**Consultation Response from KC,
Conservation & Design**

2022/93938 Piazza Shopping Centre, New Street and Albion Street, Huddersfield, HD1 2TR

Change of use from A1 (business retail and storage) to C3 (residential) 34 studio flats at first and second floors and external alterations

Date Responded: 19.01.2023

Proposed Front Elevation

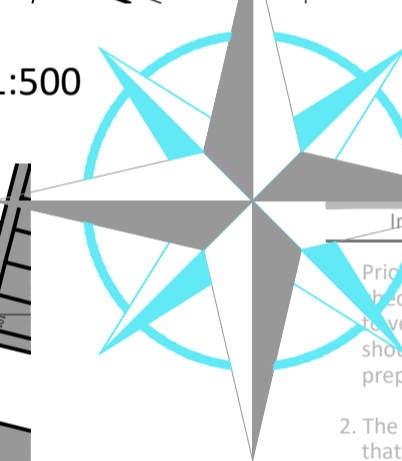
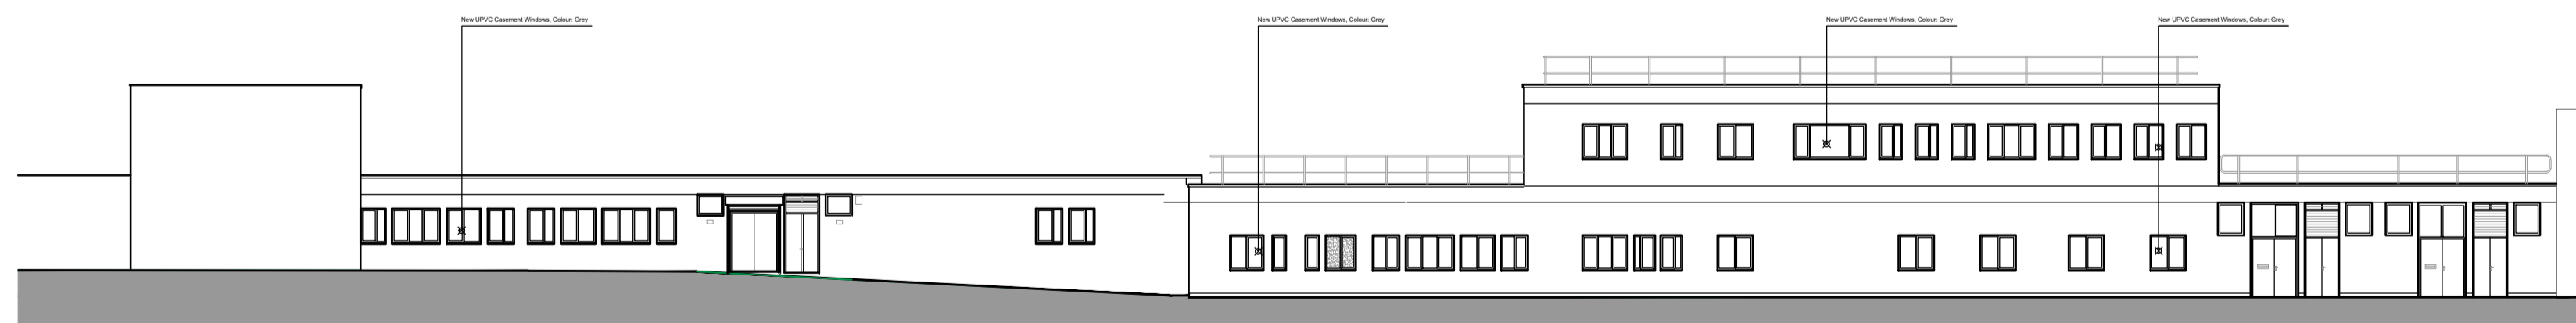
Conservation would raise no comments or concerns to the proposed change of use, which will have a neutral impact to the setting of the Conservation Area. We would however set out that replacement windows should be of metal frames opposed to the suggested use of uPVC. Metal frames would have much improved visual appearance and a greater longevity than uPVC.
